Application No: K/55/20/PL
Site Address: 57 Coastal Road Kingston BN16 1SN
Description of works: Demolition & erection of 1 No. dwelling. This application is in CIL Zone 4 and is CIL Liable as new dwelling.

Thank you for your internet representation made on 15th January 2021 which has been recorded as an objection with the comments as follows:

Council objects to the application for the following reasons:

For ST Charles Homes LTD	
Drawing Proposed Plans&Elevations	
Project La Casa, 57 Coastal Road, West Kingston East Preston BN16 1SN	
Scale	1:100
Date	19.11.2020
Made by Arch. Grygorieva A.A.

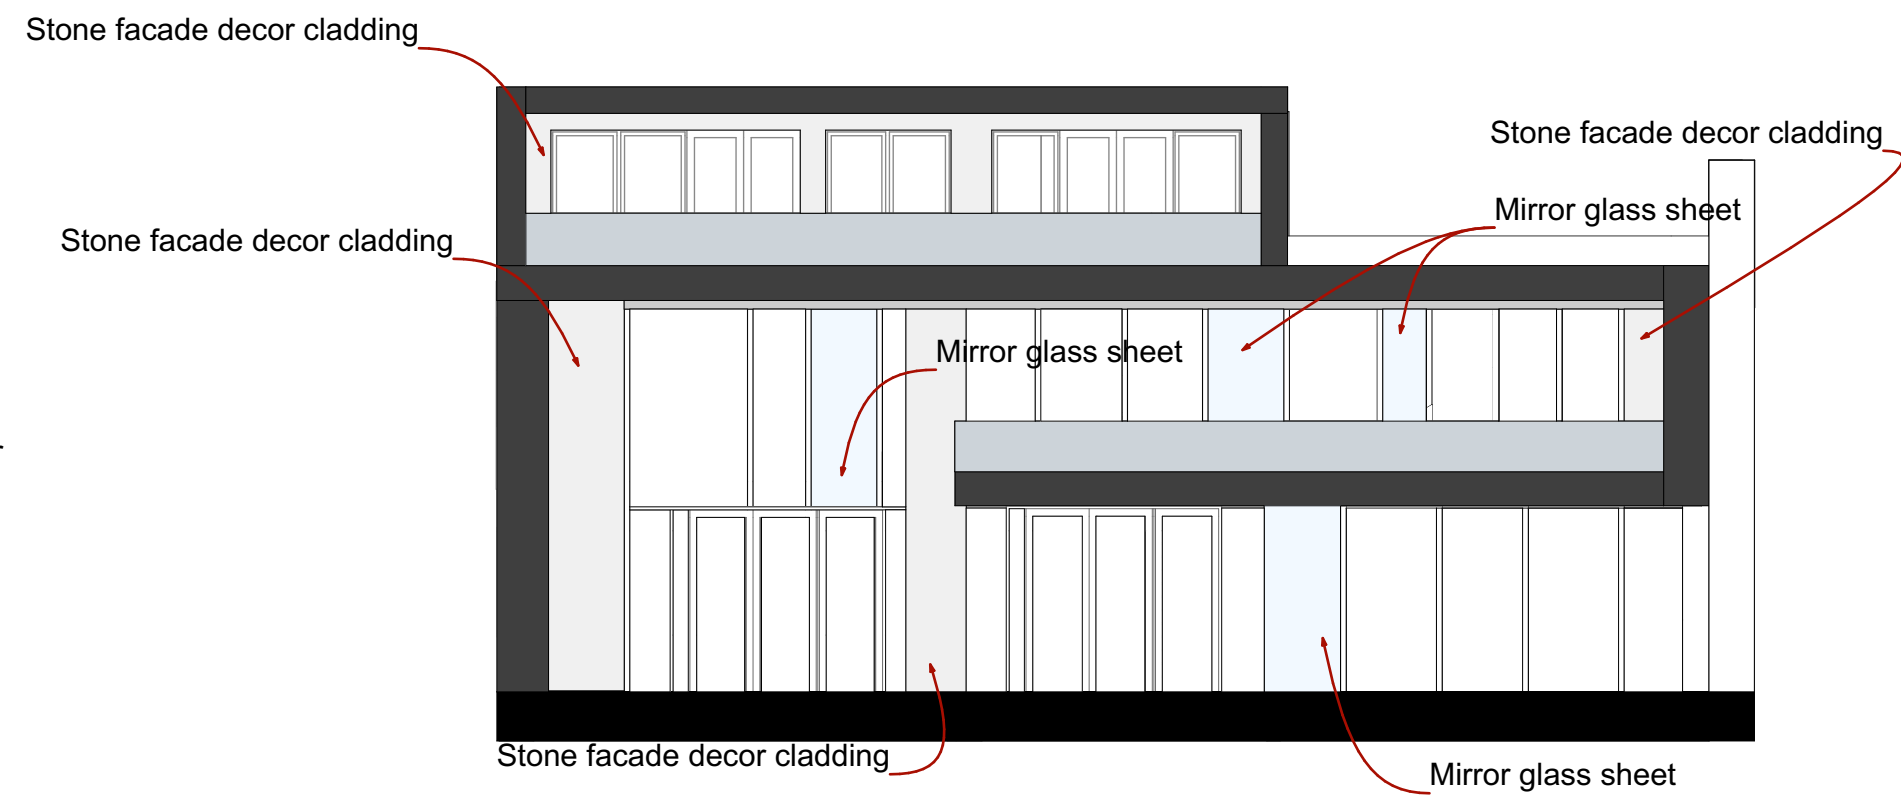
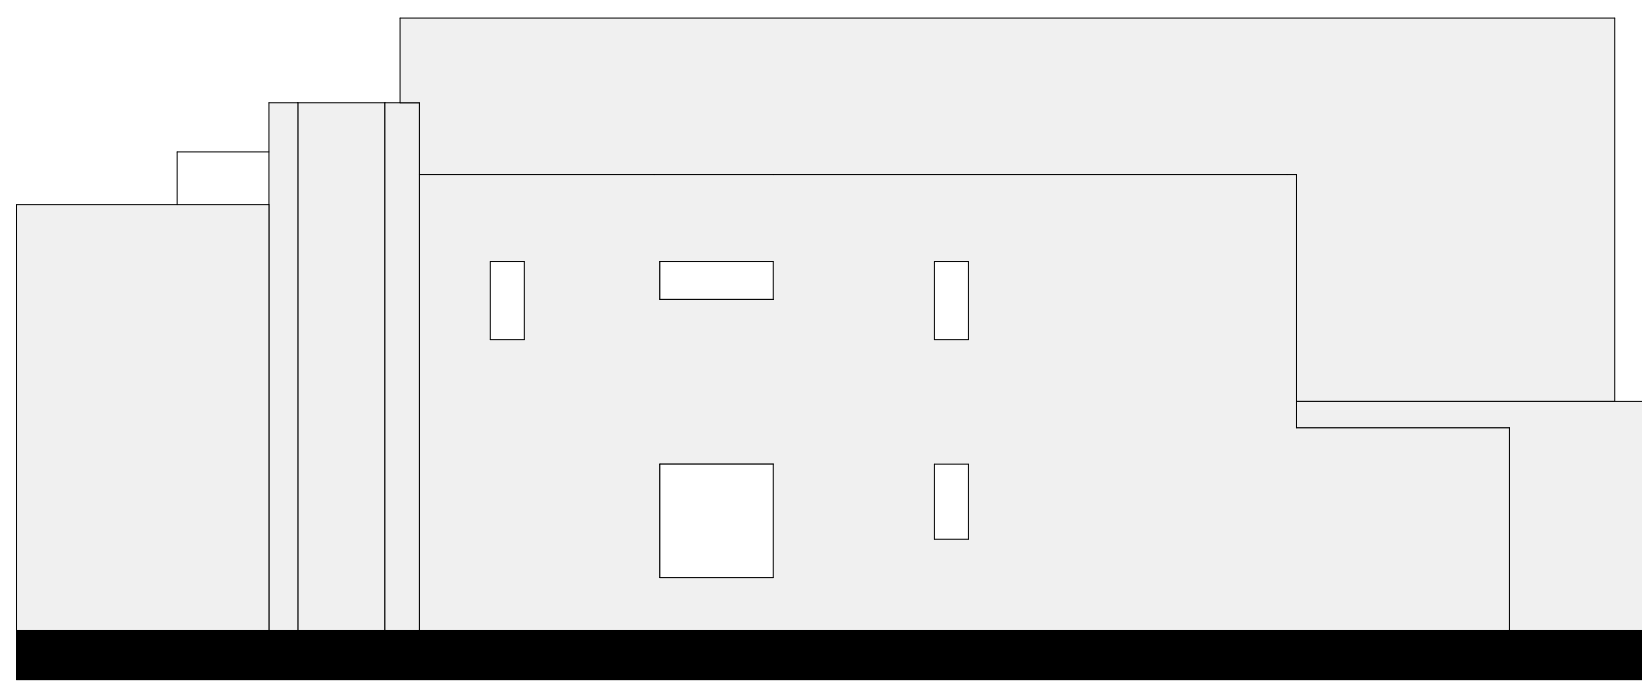
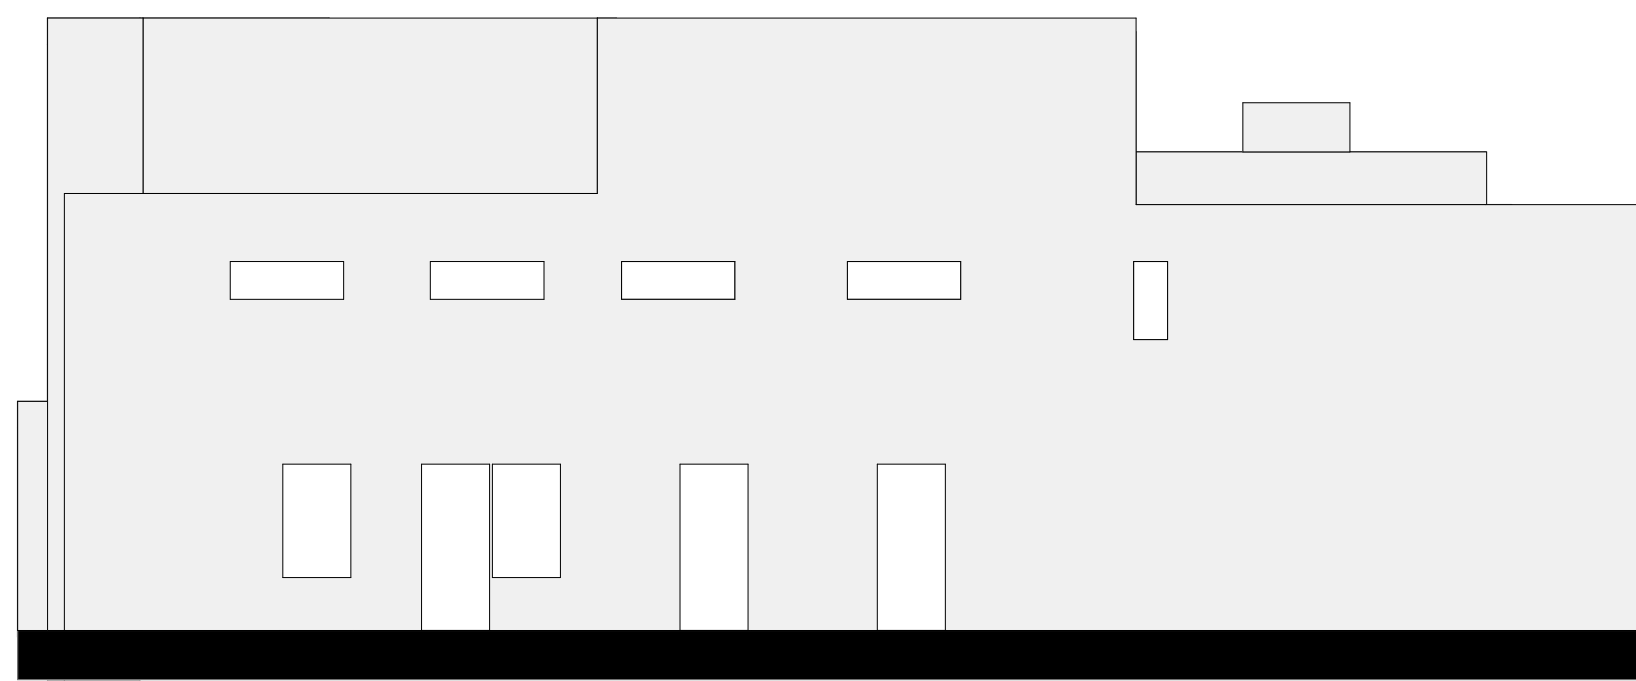
1. It is an overdevelopment of the site
2. Due to its design, increase in bulk and scale and its position across the plot, it is visually more intrusive than the existing dwelling and will overly and adversely dominate the street scene.

3. It will be overbearing on the neighbouring properties given its overall height and increase in footprint. The height should not exceed the ridge height of the existing dwelling (14.89)

5. It is out of character to the design of other houses in the vicinity.
6. It is intrusive to neighbouring properties affecting their natural light and privacy.

For	
ST Charles Homes LTD	
Drawing	Scale
Site plan	1:500
Location plan	1:1250
Section A-A	1:100
Project	
La Casa, 57 Coastal Road, West Kingston East Preston BN16 1SN	
Date	15.06.2020
Made by	
Arch. Grygorieva A.A.

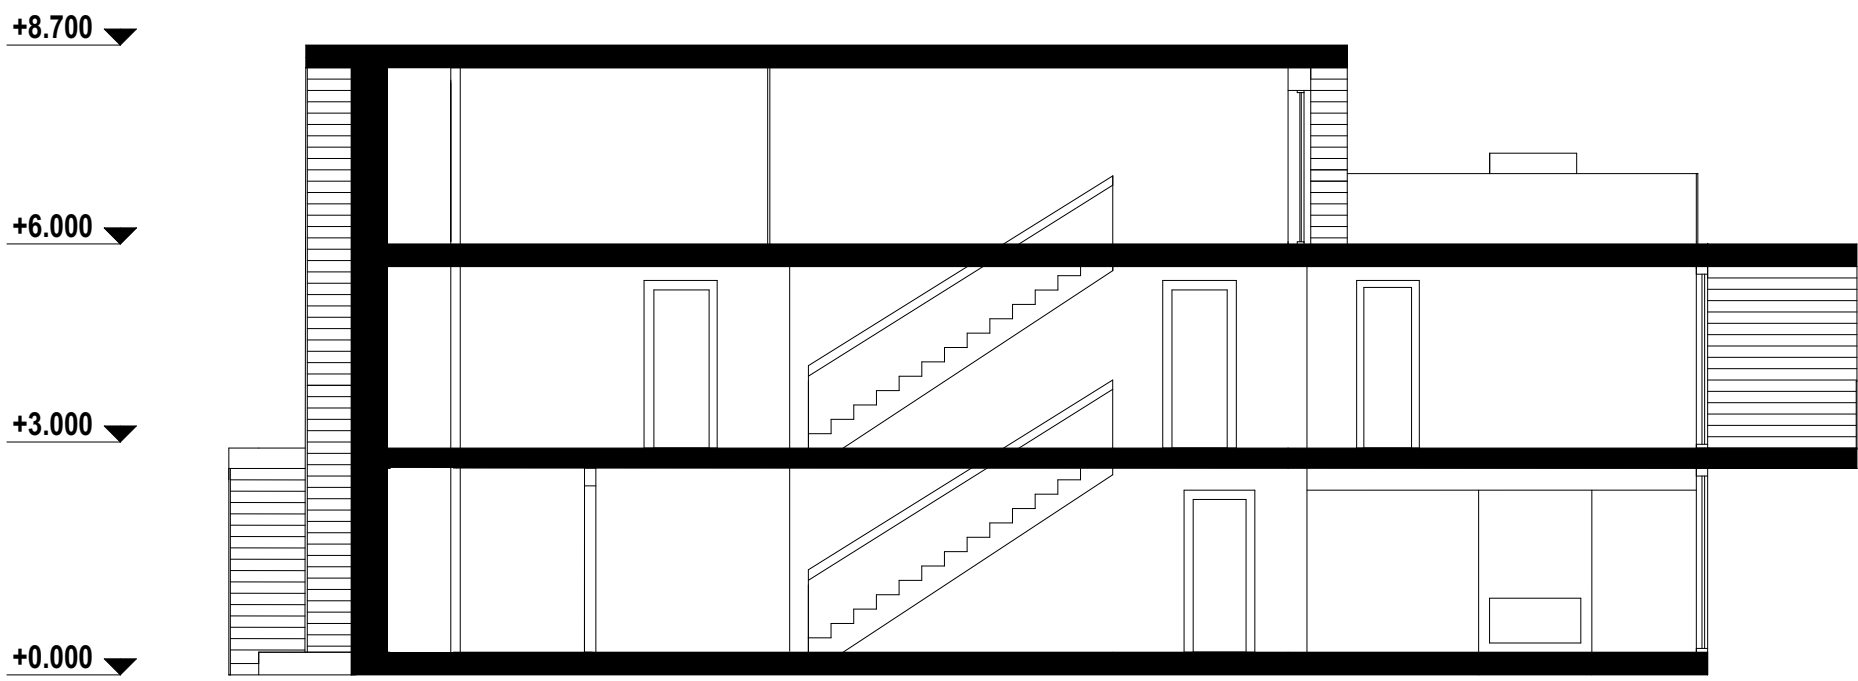
4. The build line should not extend further south than the existing. This will be detrimental to the neighbouring property and to the street scene as viewed from the West Kingston Greensward. Council considers that properties along Coastal Road and the Greensward effectively have a double frontage.
